September 17, 2018

Re: Shops @ the 24s

2424 Louisiana Blvd NE Grading and Drainage Plan

Engineer's Stamp dated: 9/11/2018 (H19D001)

#### GRADING & DRAINAGE PLAN

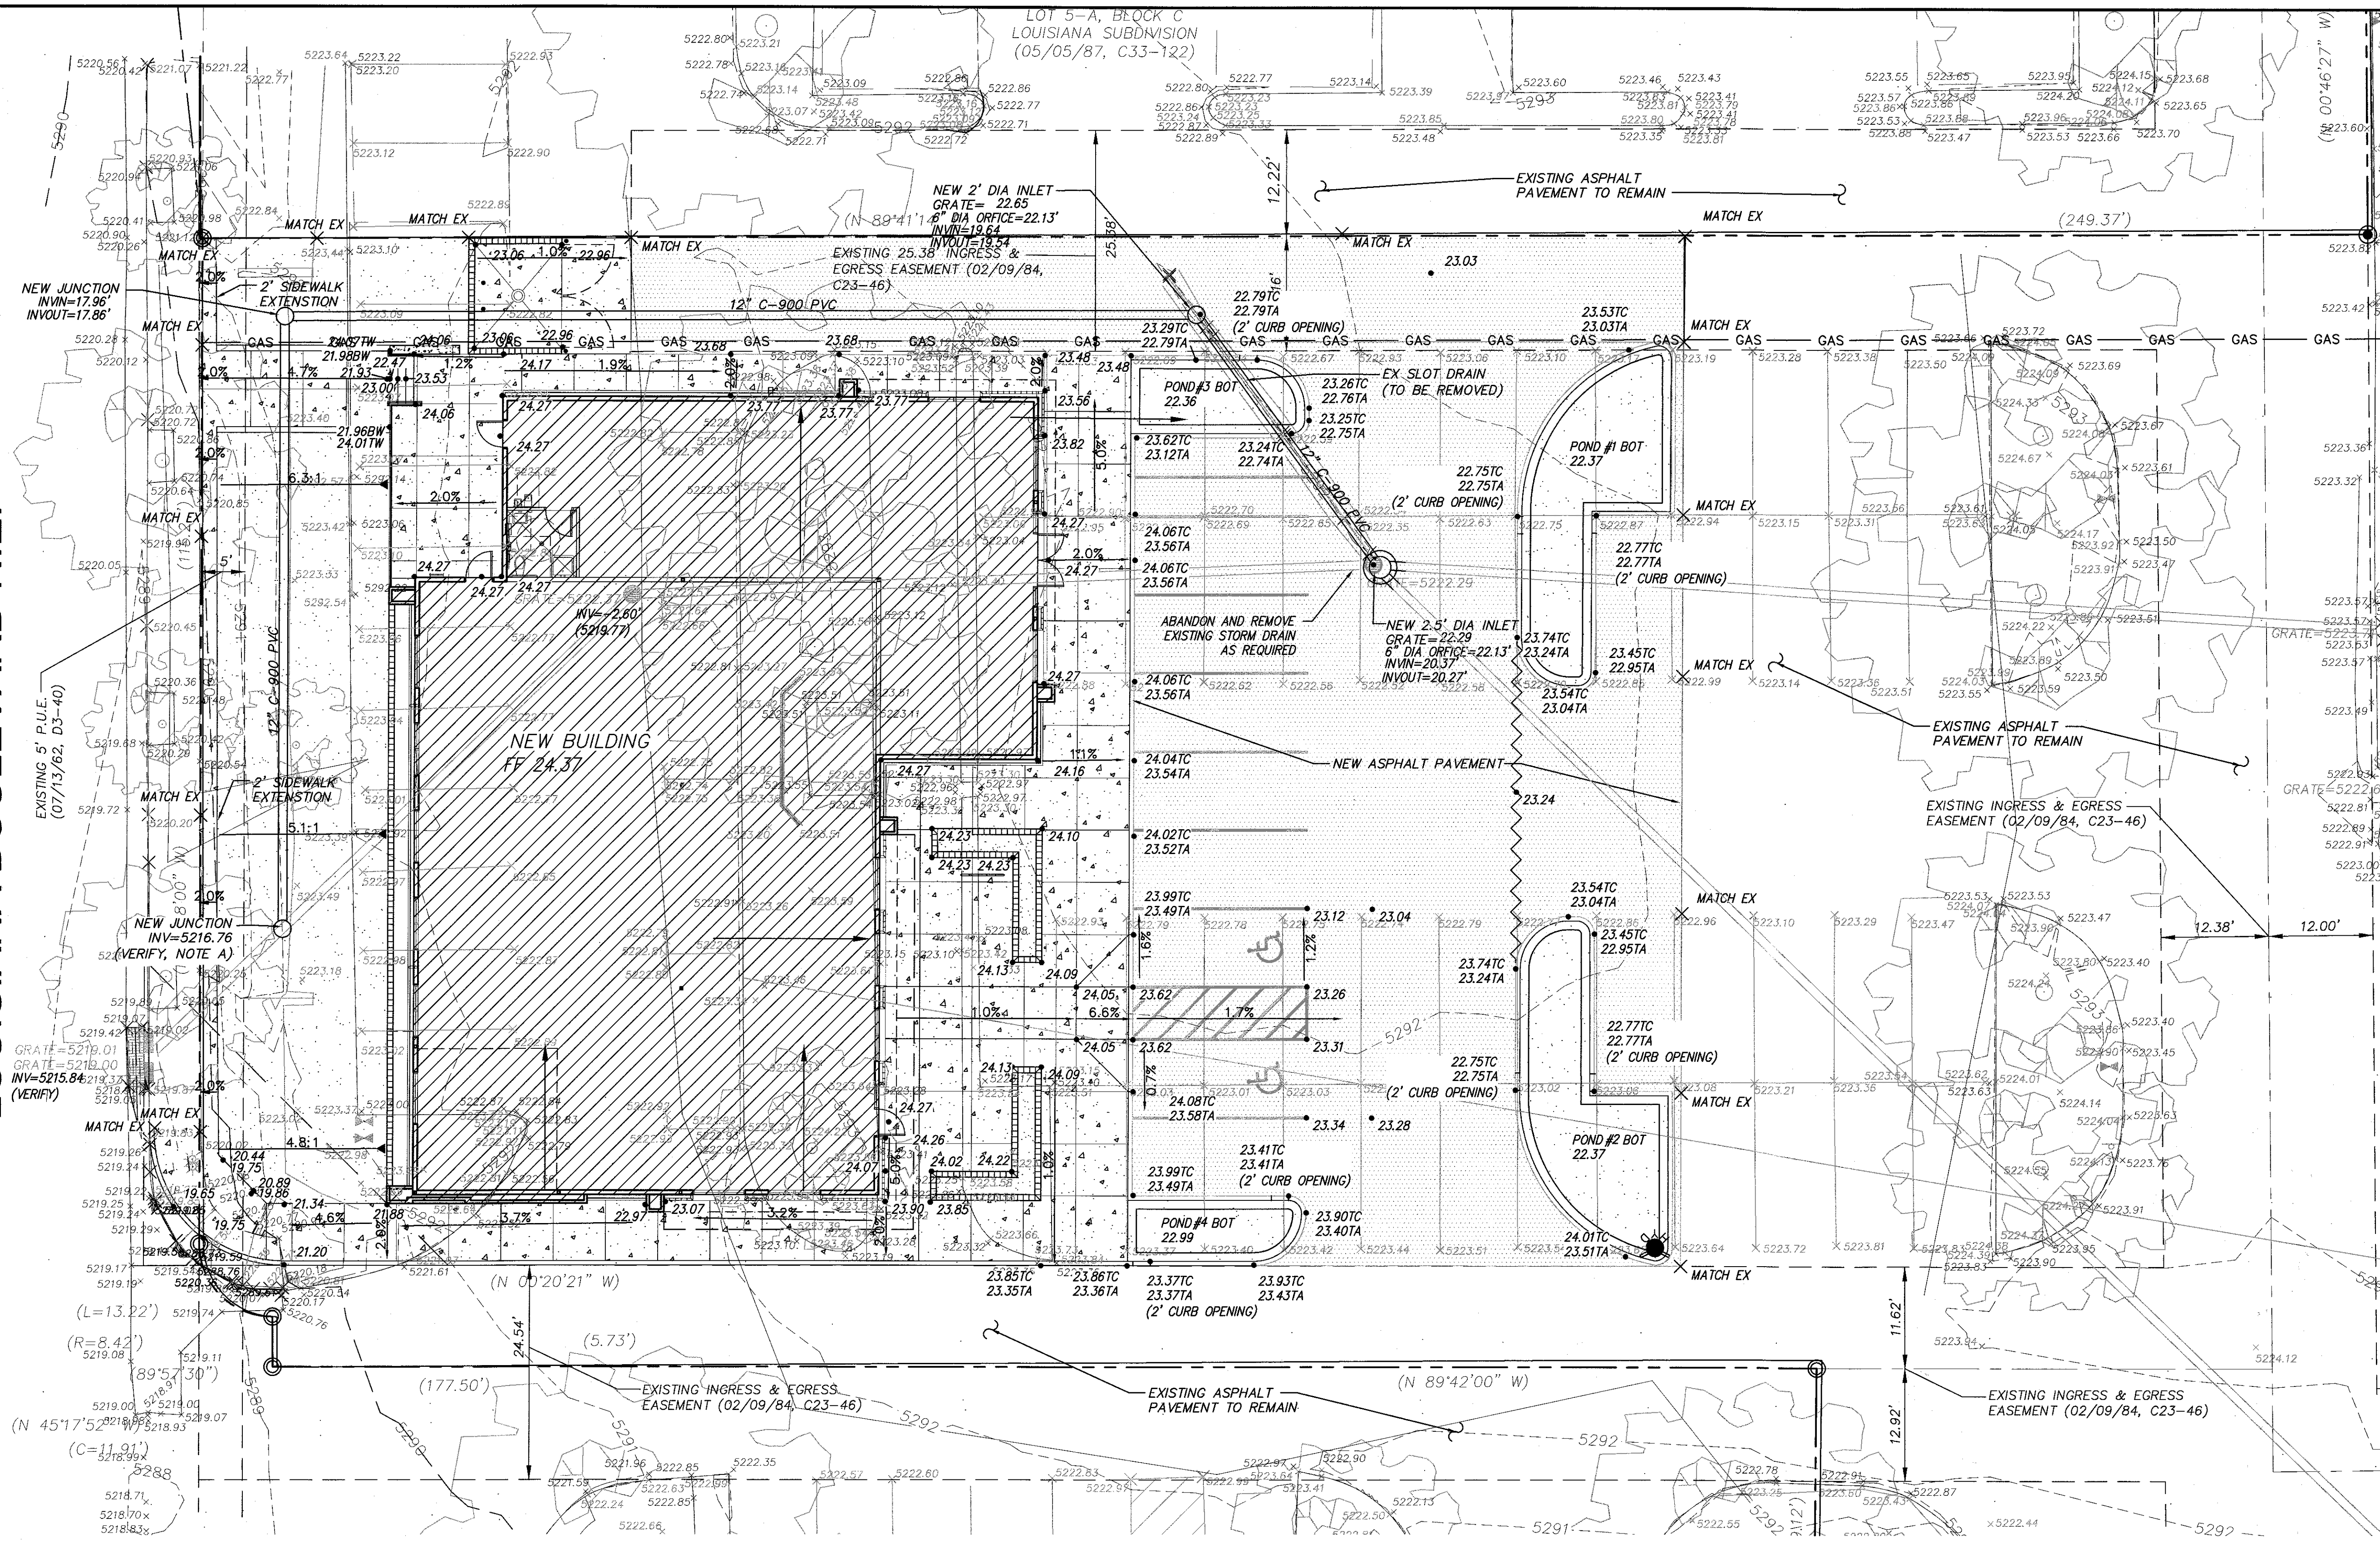
2. A Drainage Covenant is required for the detention/retention ponds and private storm drains on this lot. Add the "Hydrology Notes" from sheets C2 and C3to the exhibit. The original notarized covenant, pond exhibits (legible on 8.5x11 paper), and recording fee (\$25, payable to City of Albuquerque) must be turned into DRC (4th, Plaza del Sol) for routing. Please contact Charlotte LaBadie (clabadie@cabq.gov, 924-3996) or Madeline Carruthers (mtafoya@cabq.gov, 924-3997) regarding the routing and recording process for covenants.
